**Kittitas County**  
**Teaway Solar Reserve**

**Public Comments**  
**After April 5, 2010 – August 3, 2010**

Re: Teanaway Solar Reserve Project

TO: Anna Nelson  
FROM: Christina Wollman, Planner II *CW*  
DATE: June 22, 2010  
SUBJECT: Teanaway Solar Reserve SEPA Comments

**FIGURE 3**  
**Proposed Site Layout**  
 Transportation Road Plan  
 Teanaway Solar Reserve  
 Kittitas County, Washington

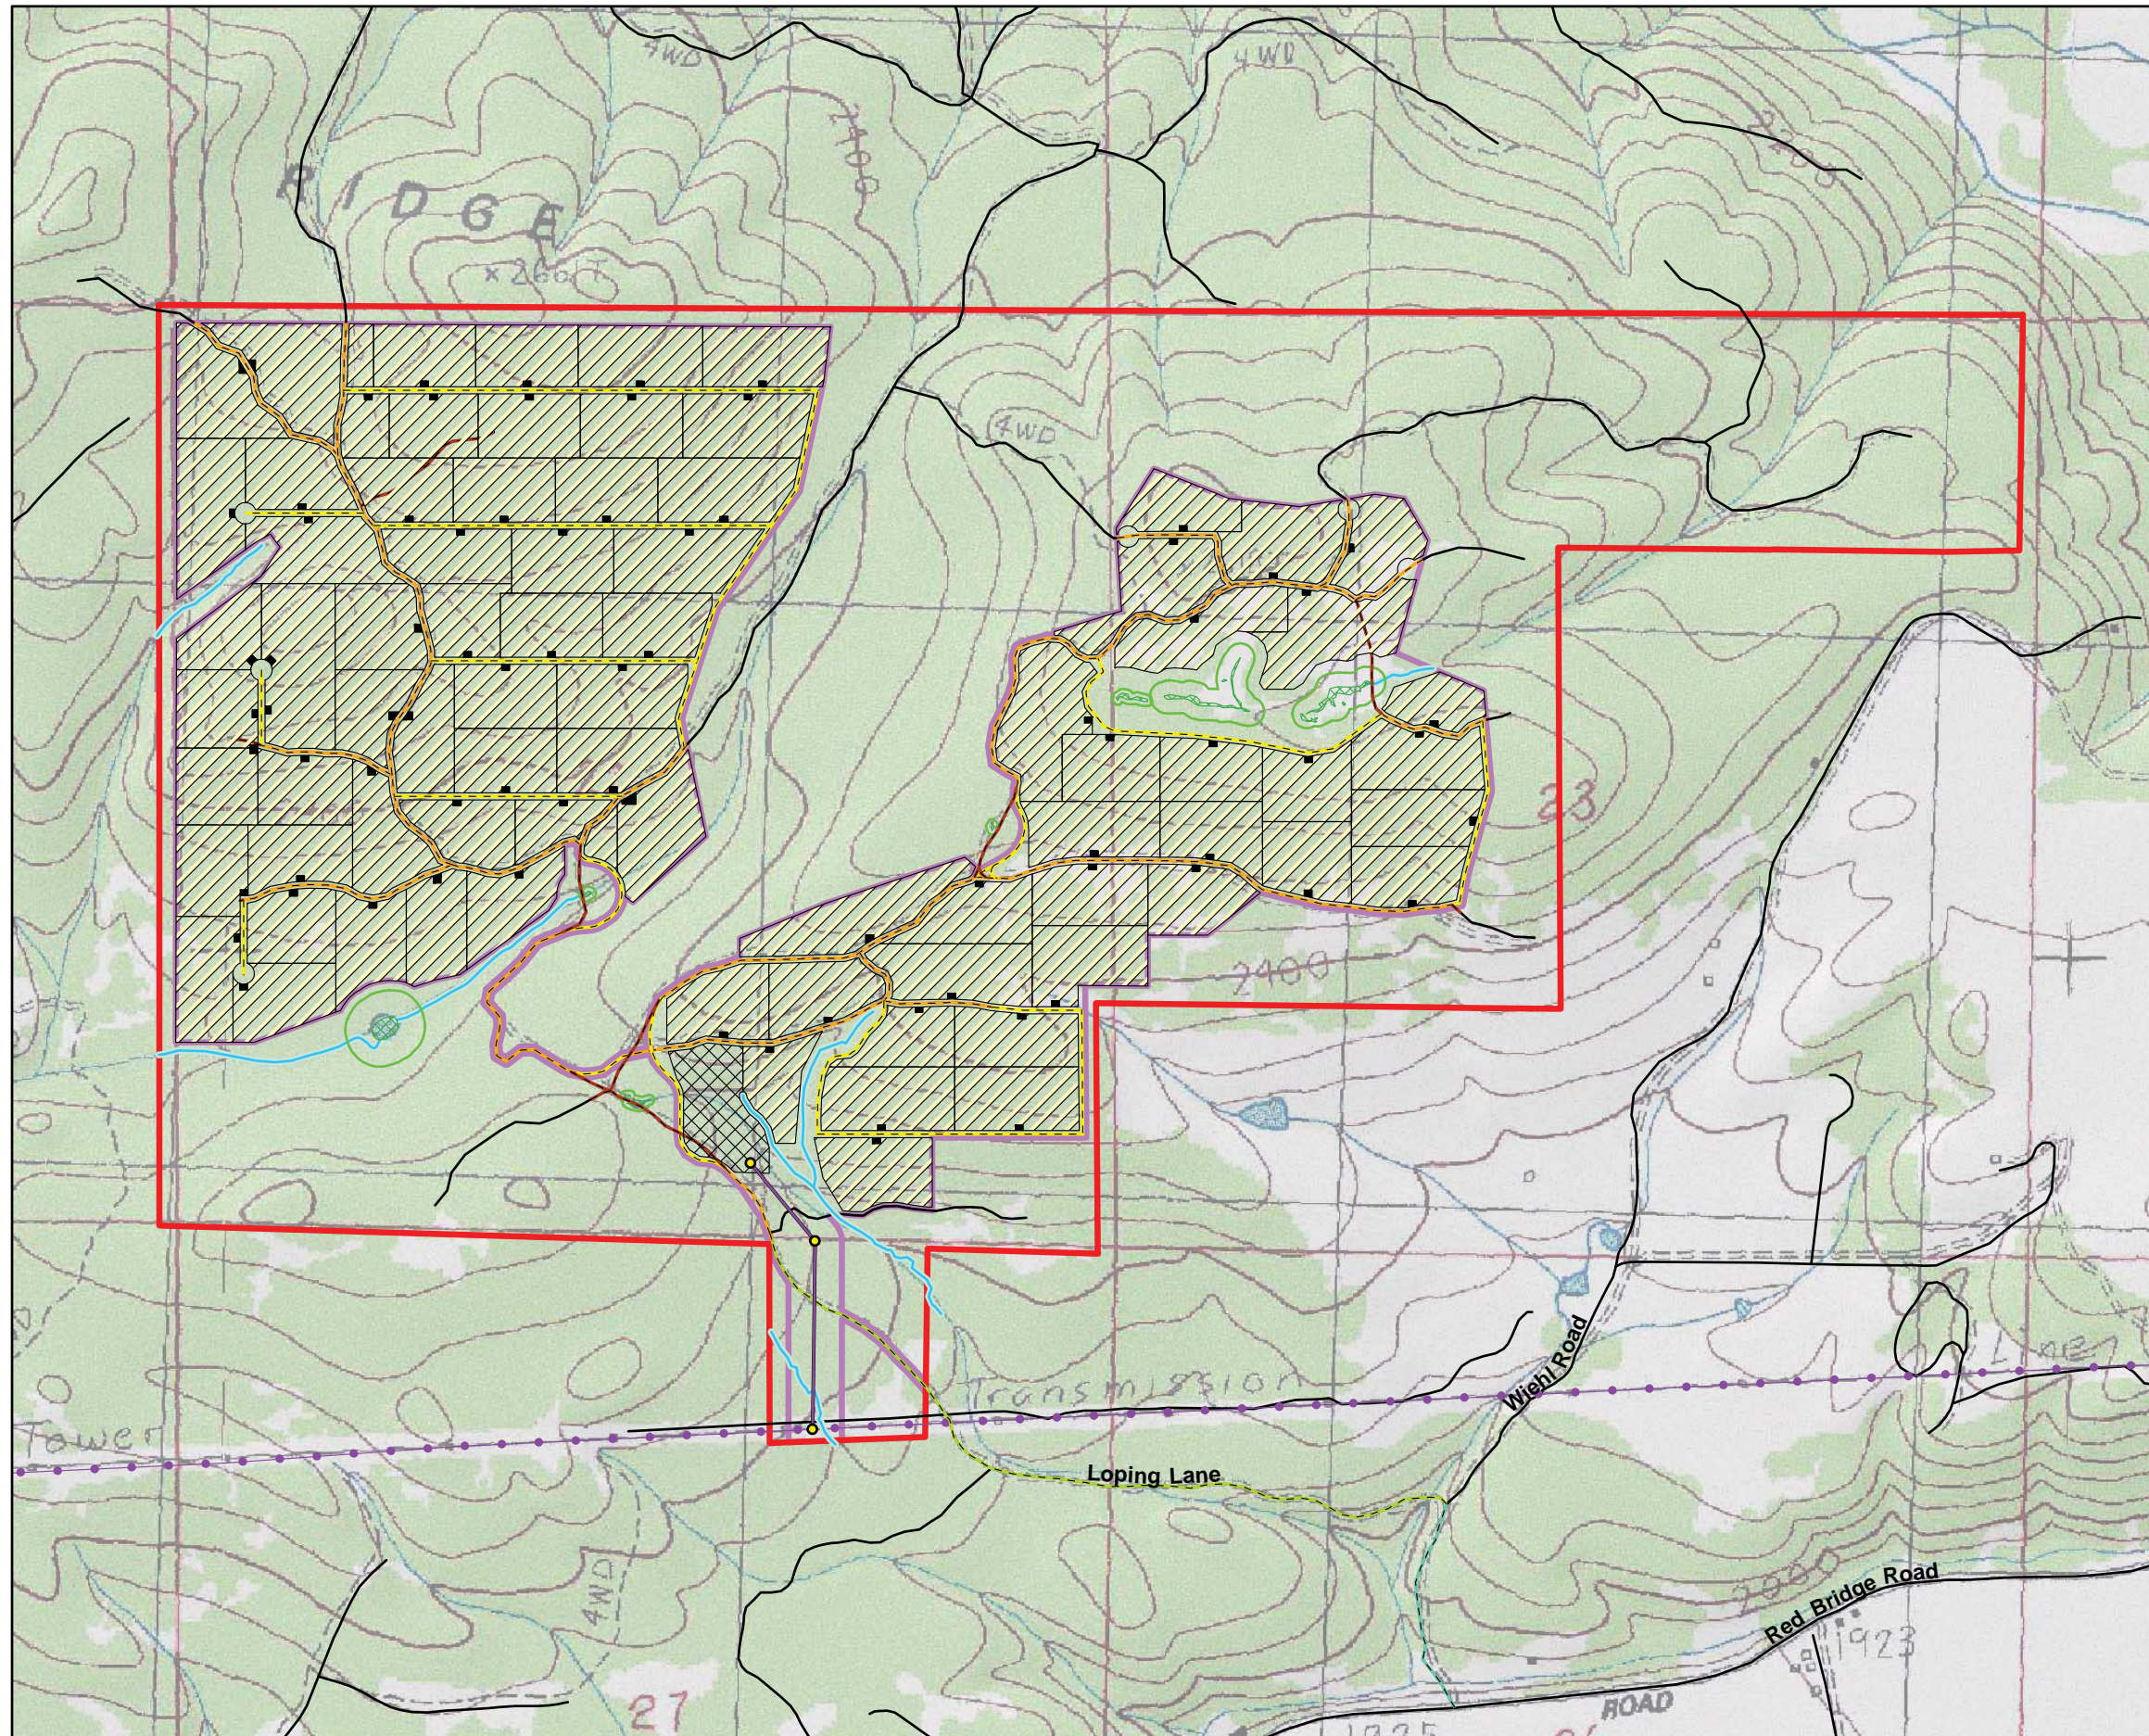
- The minimum road width shall not be less than 20' in width. The spur roads may have a road width of 16' with 4' turn-outs placed approximately every 1000 feet.

- All cul-de-sacs must have a minimum turning radius of no less than 50'.
- A rescue toboggan with all required accessories, i.e., tow bar w/ spray guard, stretcher, etc., shall be made available to emergency services and stored in a readily accessible area in the operations and maintenance facility on site.

- A 50' cleared area shall be maintained around the panels, with an additional 50' of area with reduced natural vegetation. Trees greater than 4" in diameter are to be limbed up, ladder fuels are to be removed, dead fall is to be removed, etc.

TYPICAL ROAD SECTION

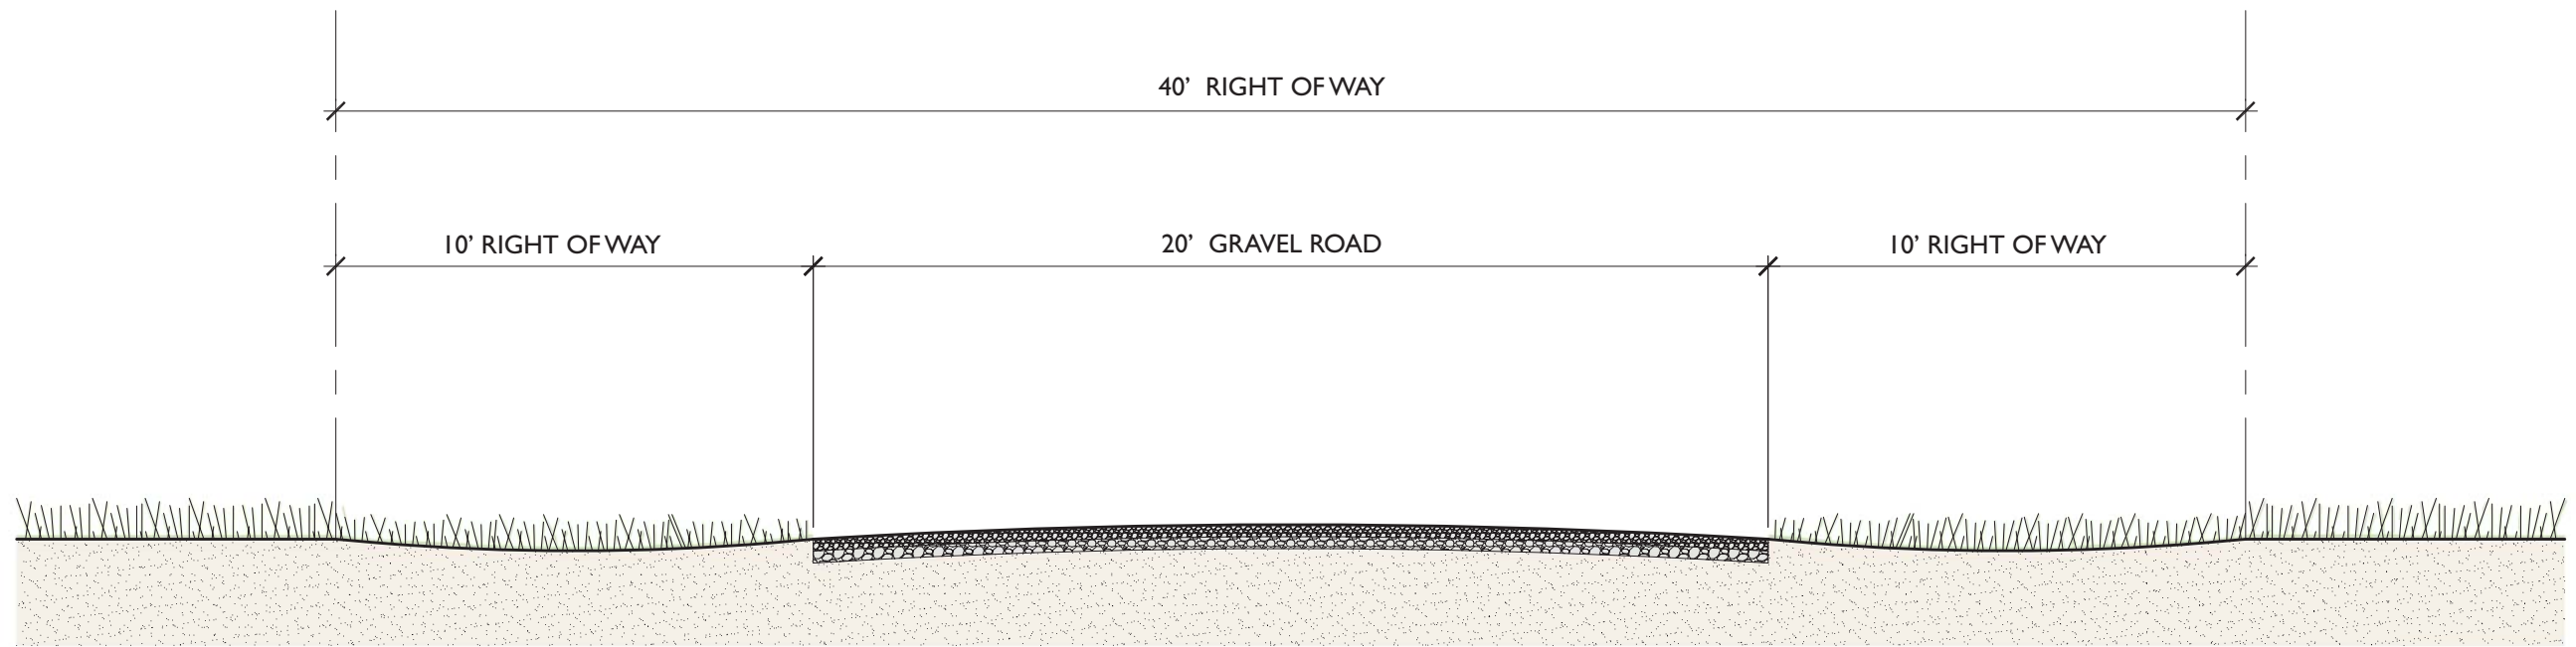
2. Within the project boundaries, the primary access roads shall be constructed with an all-weather surface and be a minimum of 20-feet wide. Secondary roads shall be a minimum of 16-foot wide, and a turnout provided every 1000-feet, or if the section of roads is less than 2000-feet the turnout shall be in the middle of the section. Turnouts shall be an additional 5-feet of driving surface for a length of 50-feet. Primary and secondary roads are those defined in Attachment F of the Development Agreement. Changes to the layout must be approved by County staff.

3. The turning radius at all corners shall be a minimum of 28-feet. Cul-de-sacs shall have a minimum driving surface radius of 50-feet.
4. Primary access roads throughout the site shall be kept clear of snow for emergency access.
